Your ref
Our ref TL /3/2013/0416
Date 12th June 2013

Planning application no: 3/2013/0416

Proposal: Outline Planning Application for the erection of four houses.

Location: Land adjacent to Manor Barn Rimington Lane Rimington BB7 4DT.

Drawing Title
Existing topographical site survey

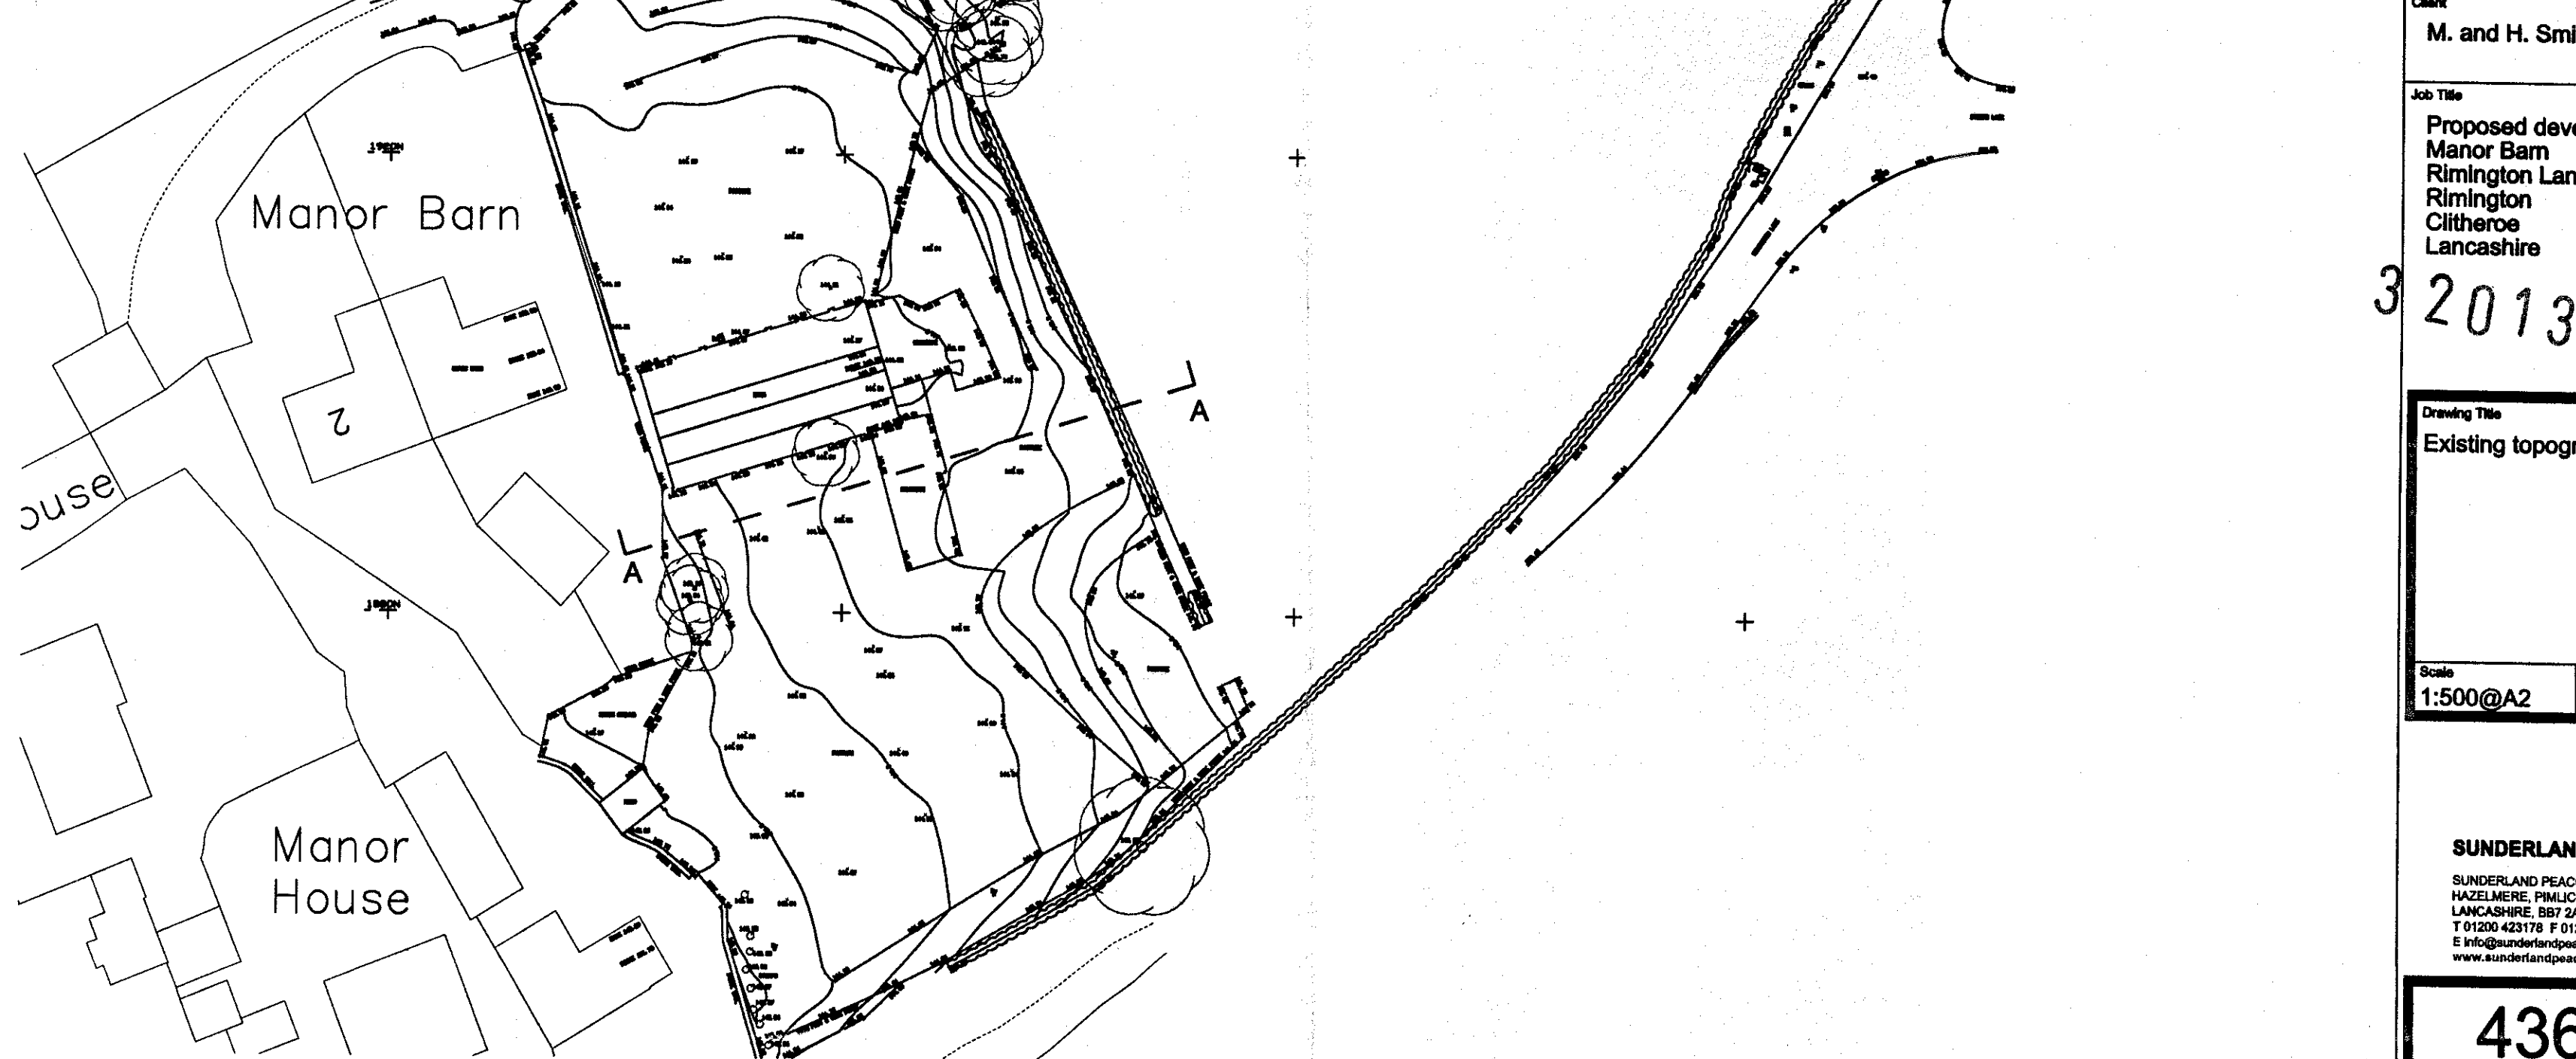
At the access off Rimington Lane, there is a field access gate and next to this the driveway is widened out. This will act as another passing place. However in order to facilitate the manoeuvring of vehicles into this place, the kerbing immediately to the west of the gate should be realigned to create an easier curve for vehicles to drive in to this space.
